DECISION DELEGATED TO DEVELOPMENT MANAGER

Application No: H09-0924-20 **Applicant:** Mrs M Goodley
Proposal: Two storey side & single storey rear extension & alterations
Location: 35 Sluice Road Holbeach St Marks Spalding
Terminal Date: 10th December 2020

Proposed Block Plan

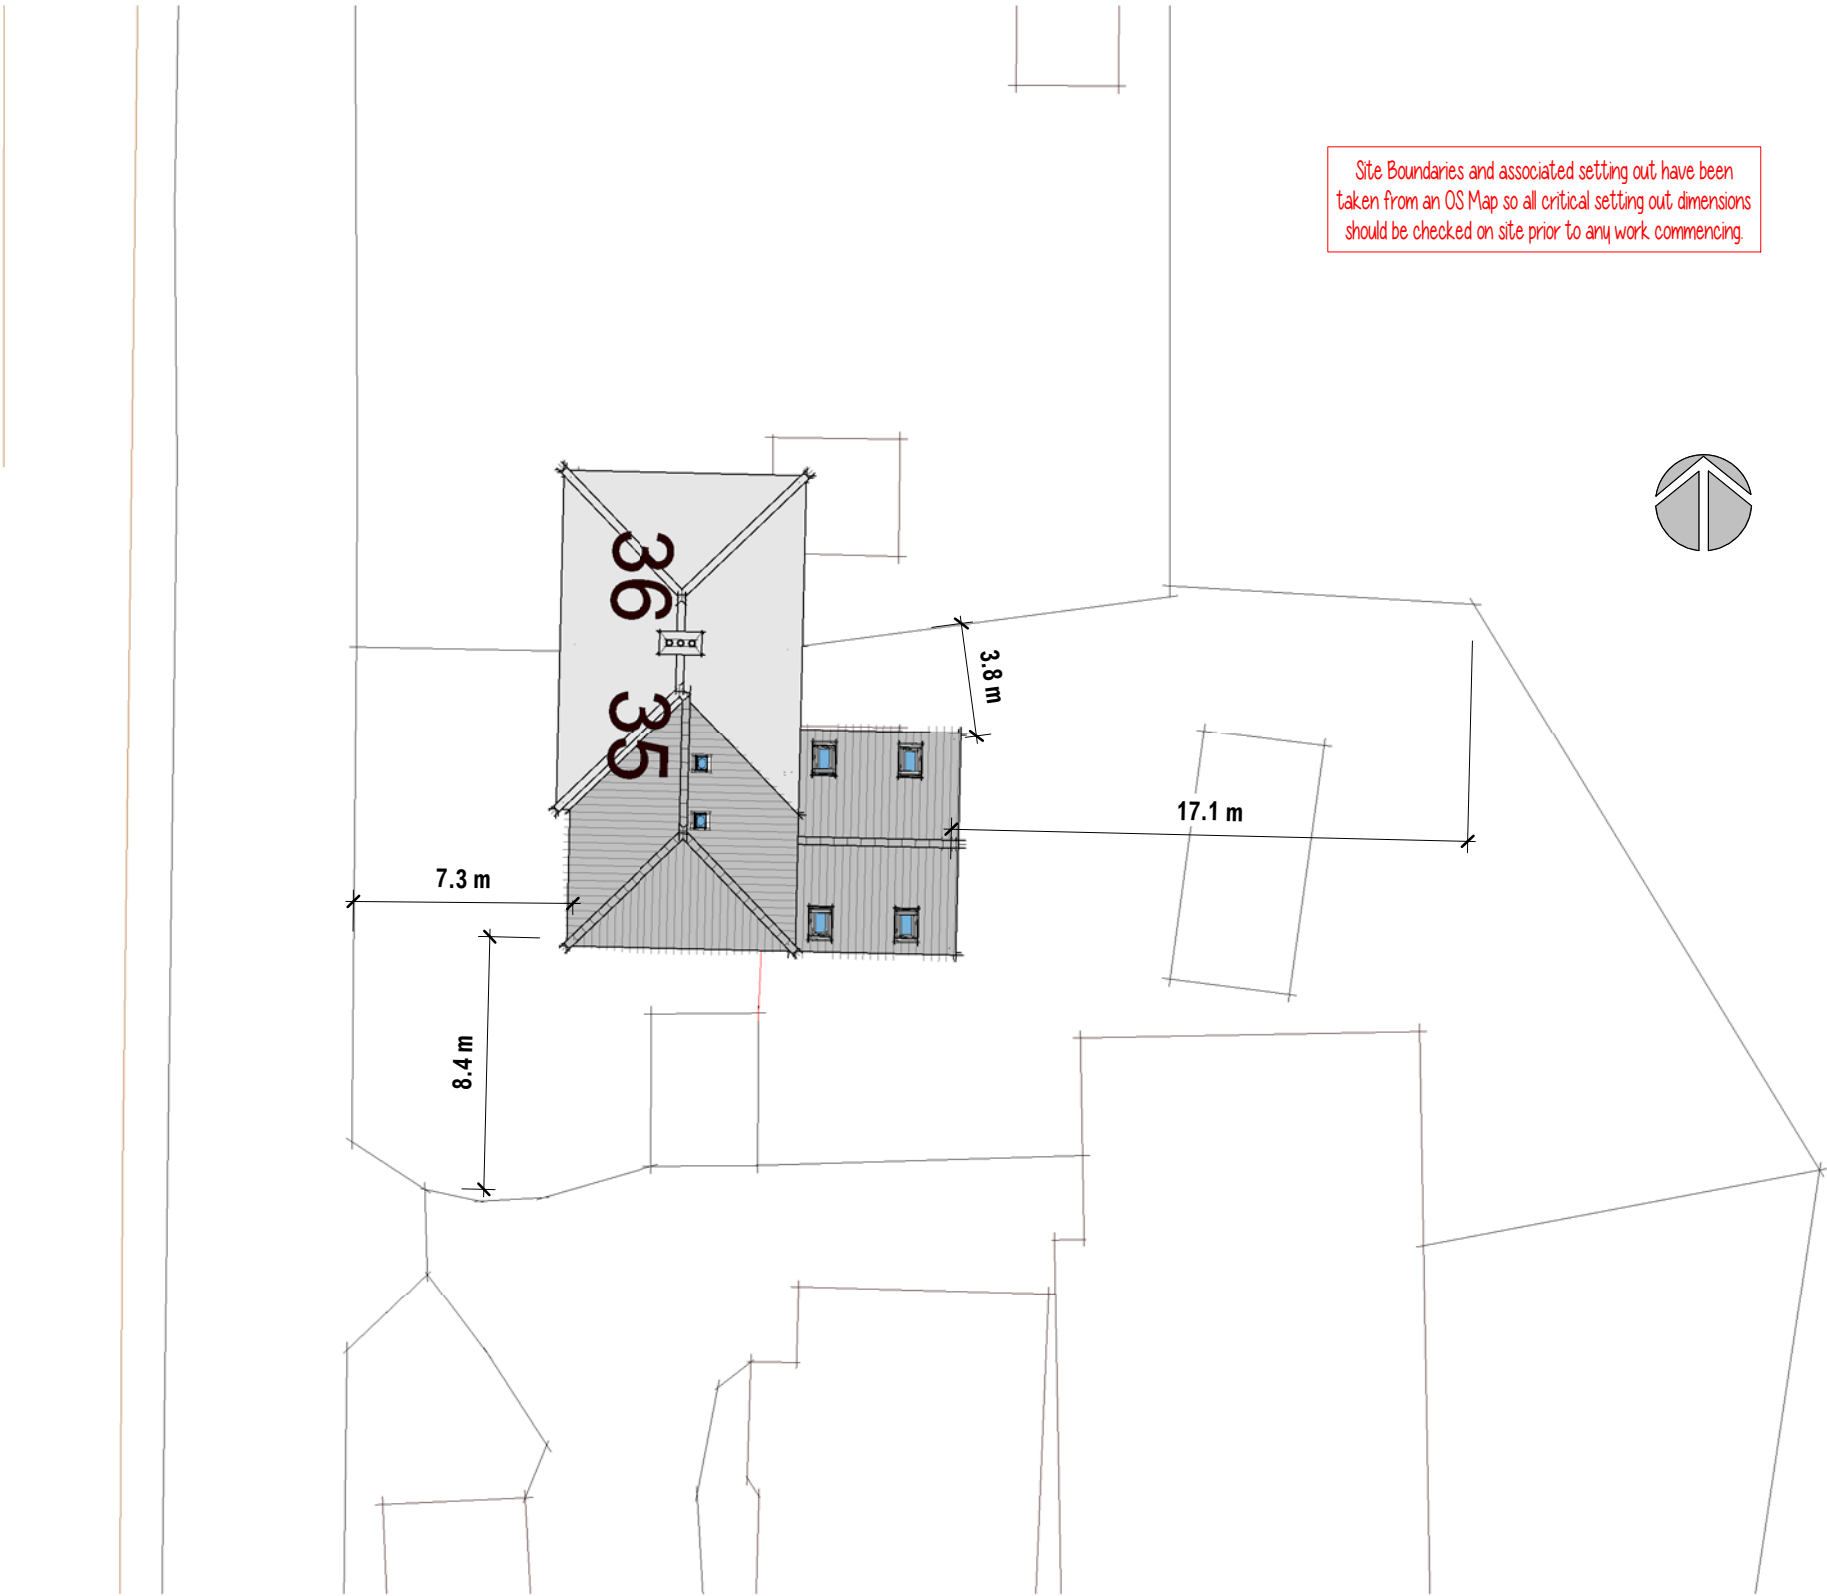
The single-storey rear extension is separated between 2.85 and 3.80 metres with the northern boundary adjoining No. 36. In view of the low rise of this house enlargement, no impact will occur upon the amenity standards of residents at No. 36.

The additional bedroom will increase the total number of bedrooms from 2 to 3. Two spaces should be provided within the curtilage of dwellings with up to 3 bedrooms. Two cars can be easily parked at the end of the driveway which is adjacent to the rear garden.

Elevation 01 - Front
1 : 100

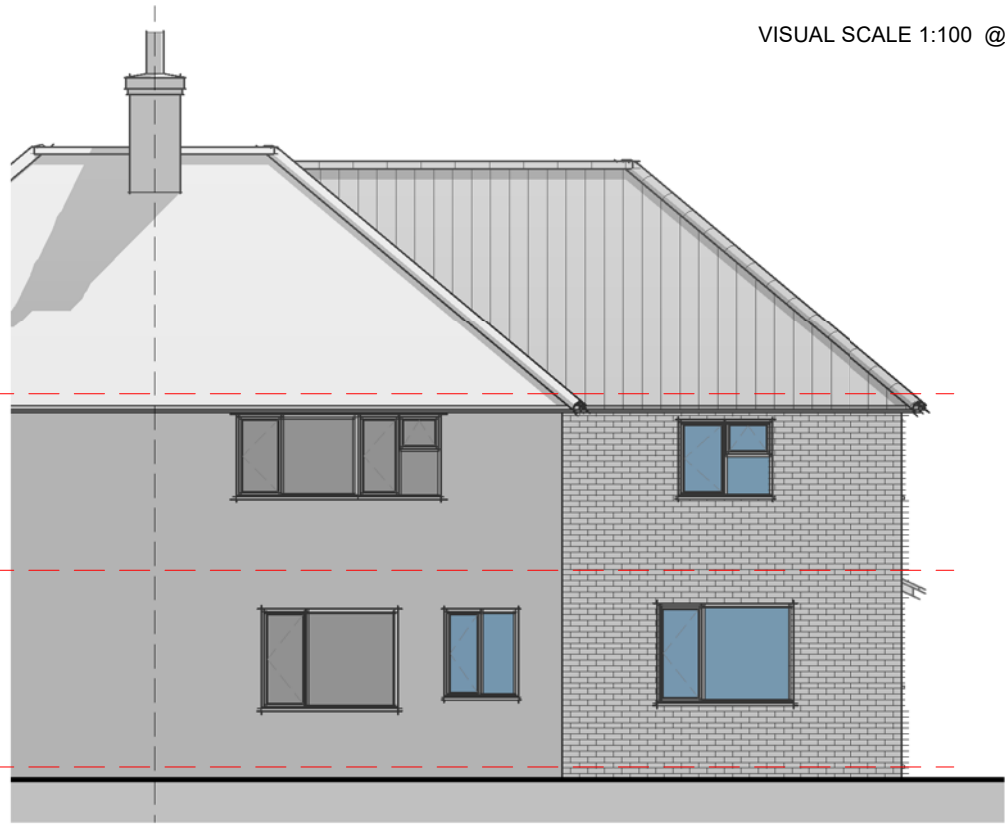
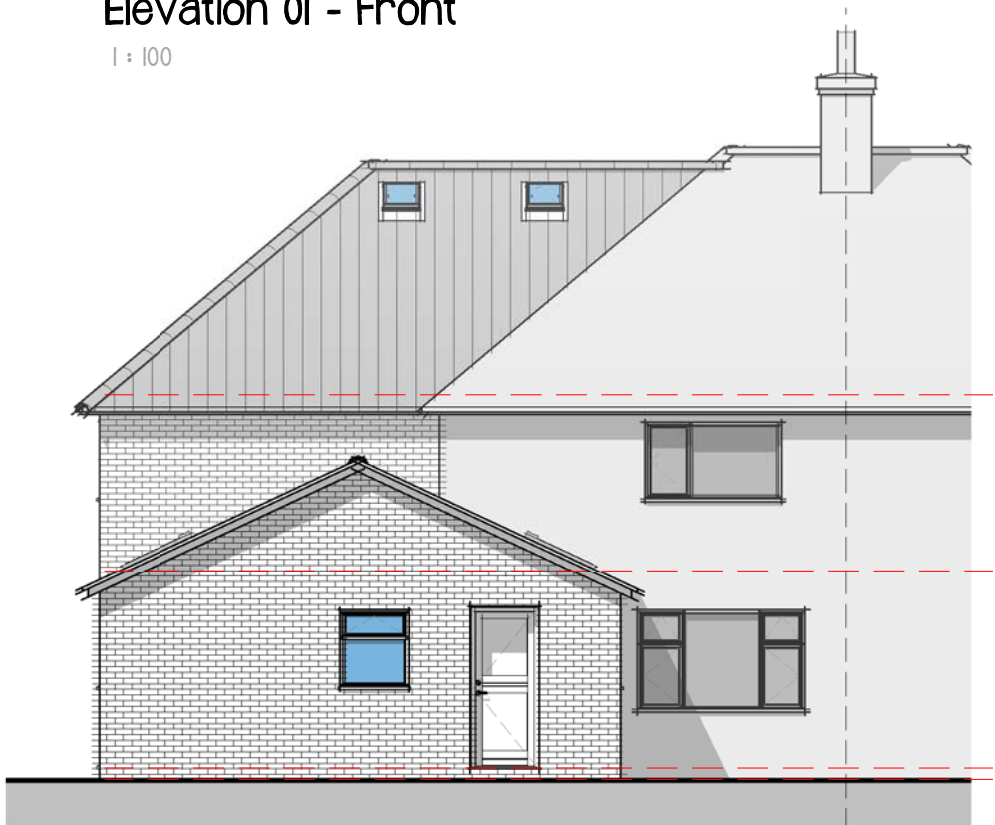
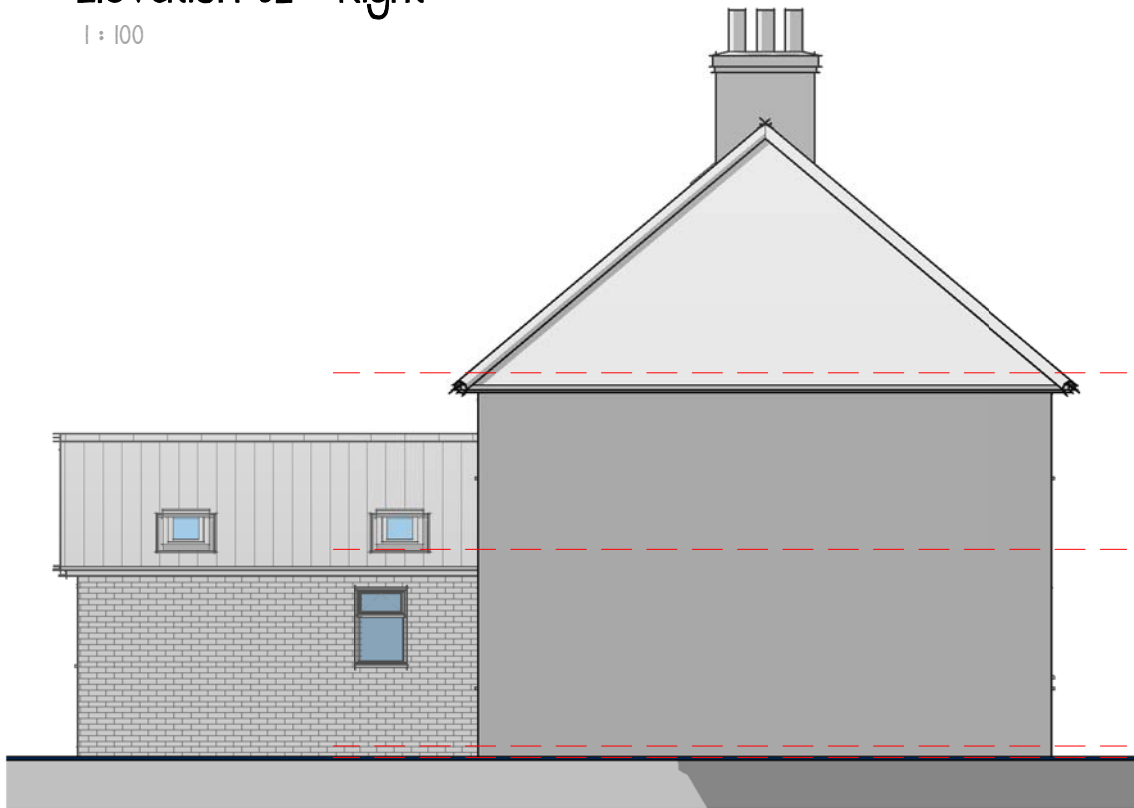
The two-storey extension will protrude 4.5 metres from the southern wall of the house and the single-storey rear extension, 5.3 metres from the original rear wall. Thus, the entire development will extend 12.45 metres from front to rear. The apex heights will be 8.45 for the two-storey extension, and 4.30 metres for the single-storey rear extension. Having regard to the dimensions of the house, the development overall will appear commensurate to the host property in terms of scale, mass and bulk.

There were initial concerns about the relationship of the two-storey extension and the host property. The height pitch is marginally 20 centimetres lower than the ridgeline of the house and the front wall is only set back 50 centimetres from the original front wall of the building. Ideally, further

subservience should have been provided given that the scale of the extension is similar to the entire building. However, on balance, the proposals are acceptable.

No external materials have been specified in the drawings neither the application form. It is assumed that the development will be matching the existing fabric of the house but that needs to be clarified prior to the commencement of works. The appearance is relevant given the position and scale of the development as well as the property age. A planning condition is recommended requesting details of external materials.

Proposed Ground Floor

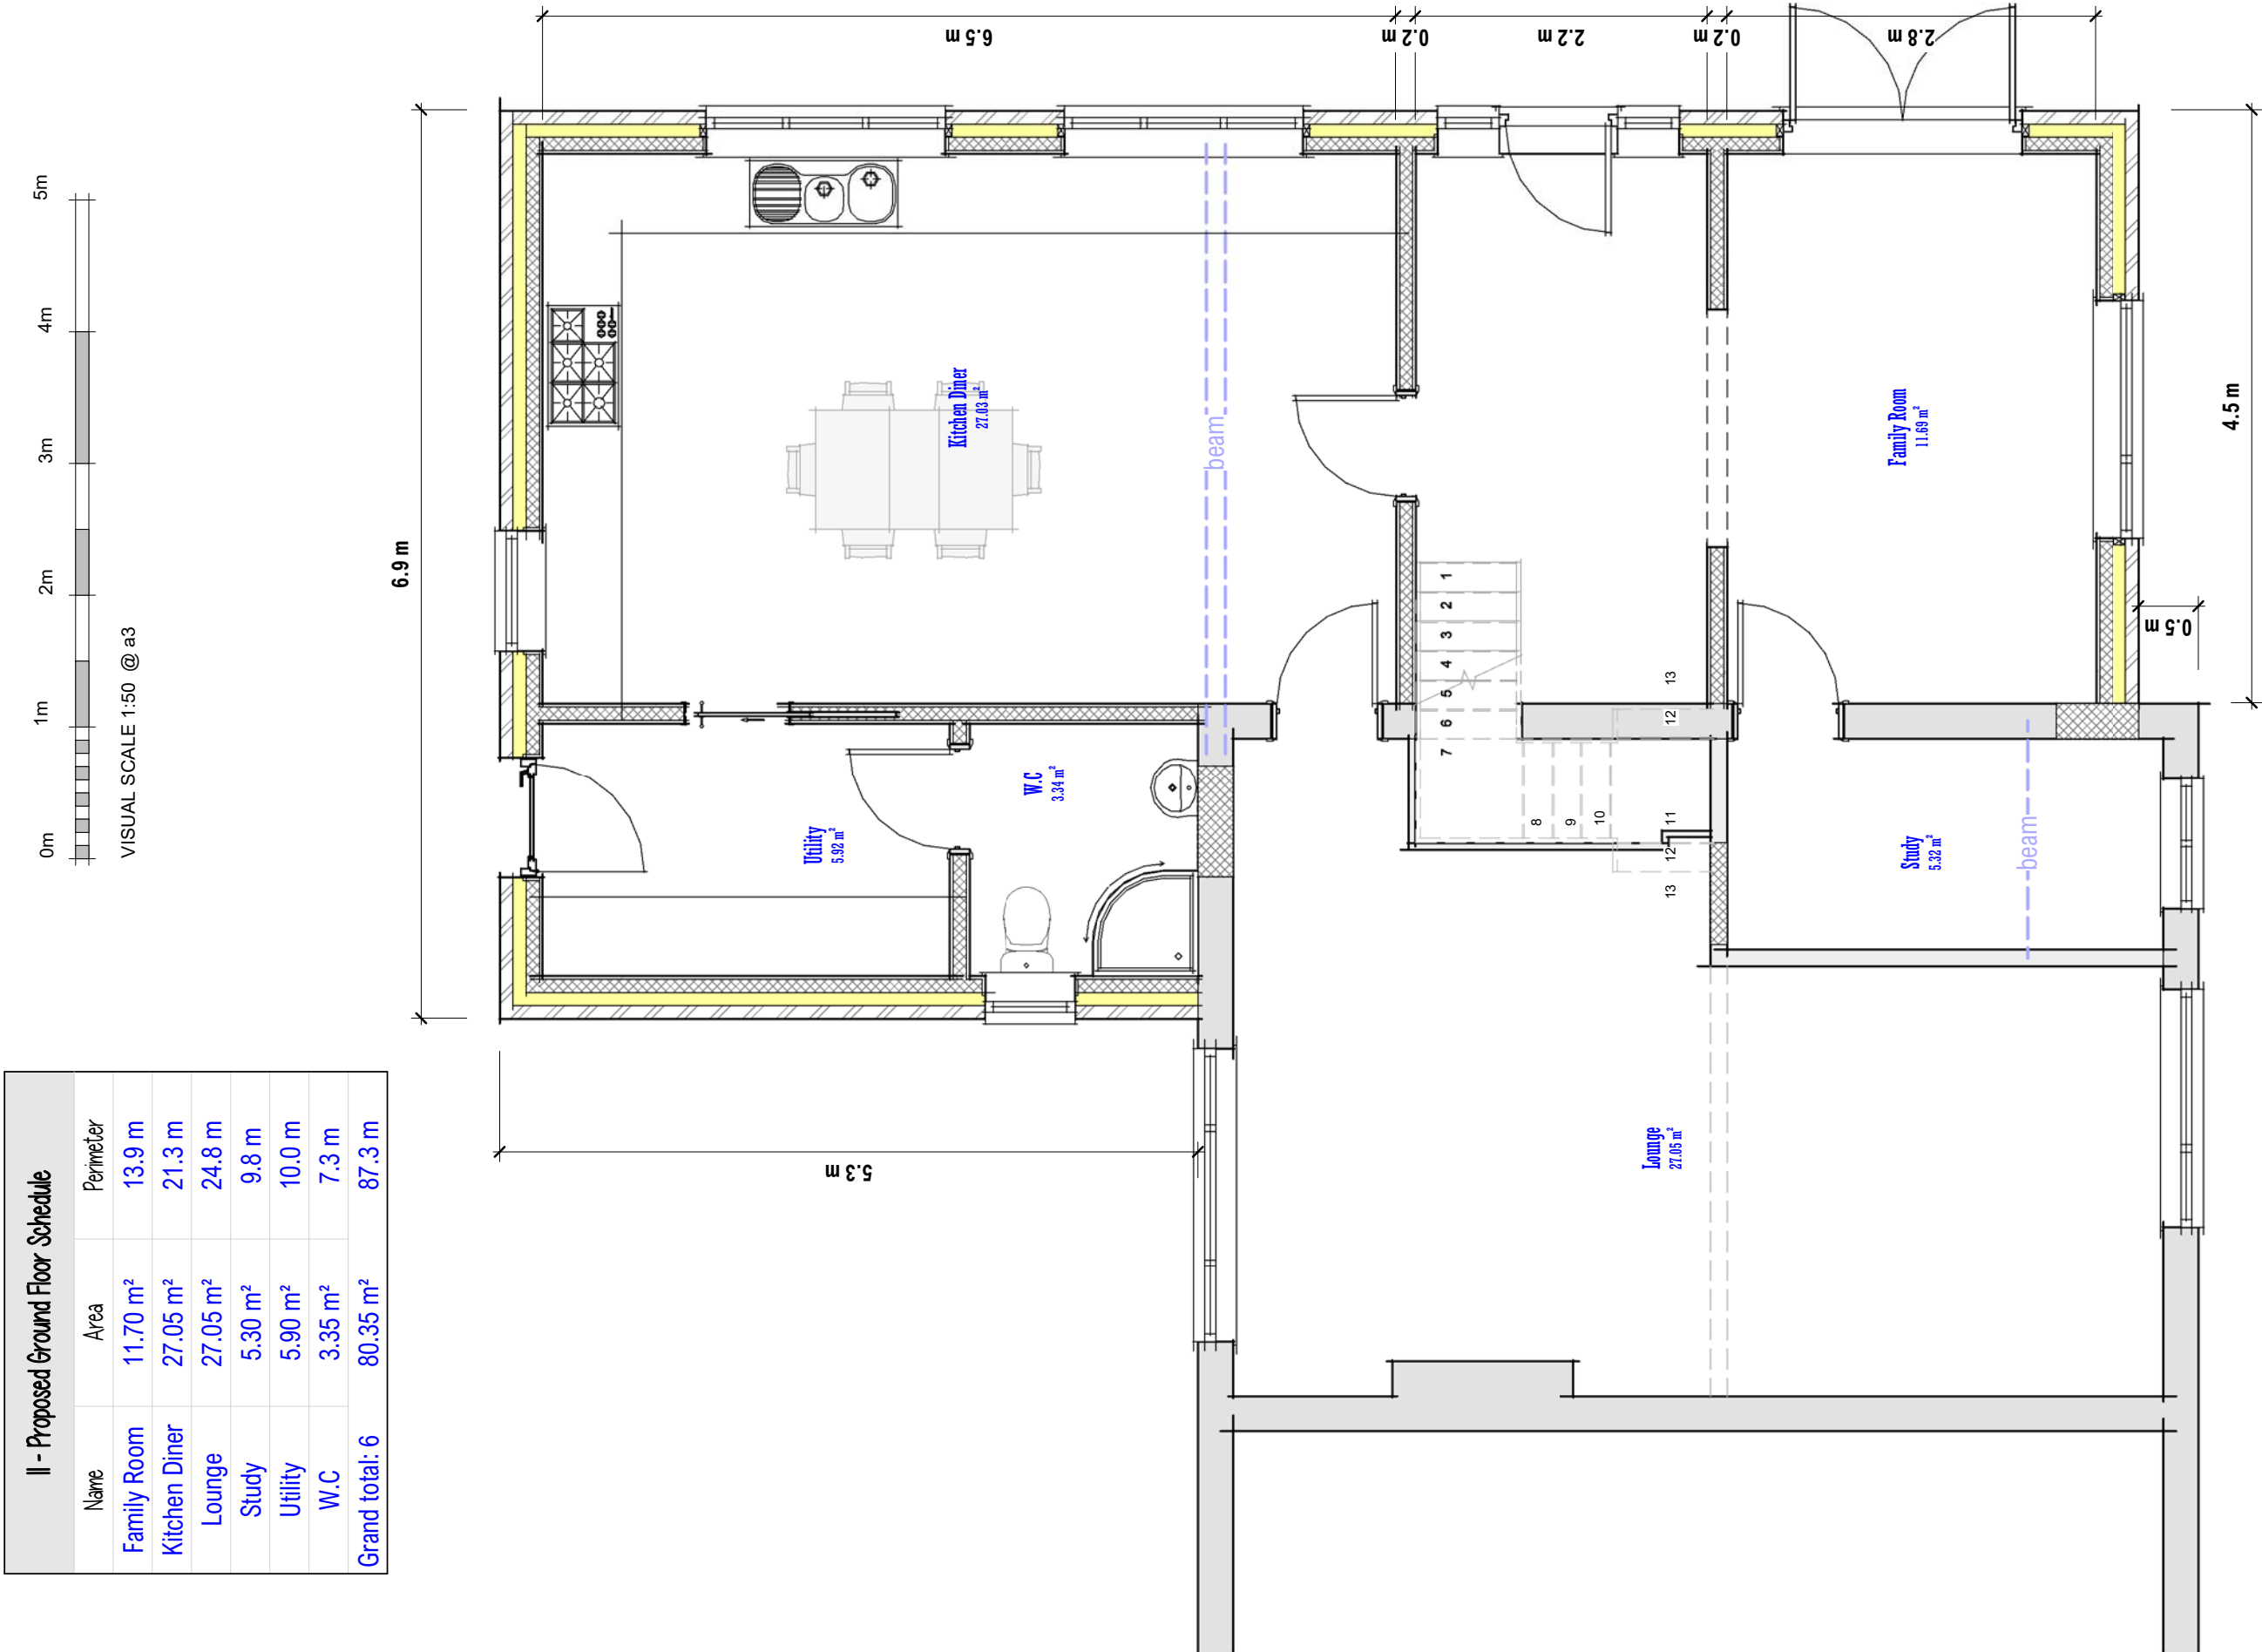
Internally, the development will entail the increase of floorspace to accommodate mainly a large open kitchen/dining room on the ground floor level and new ensuite for the front bedroom and one further bedroom and bathroom on the first floor level. Internal alteration comprising wall demolition and new openings will be accordingly carried out to ensure accessibility between the existing rooms and the new ones. In view of these aspects of the proposal, the purpose of the development is to meet the needs of the householders in keeping with the residential nature of the property and its immediate surroundings.
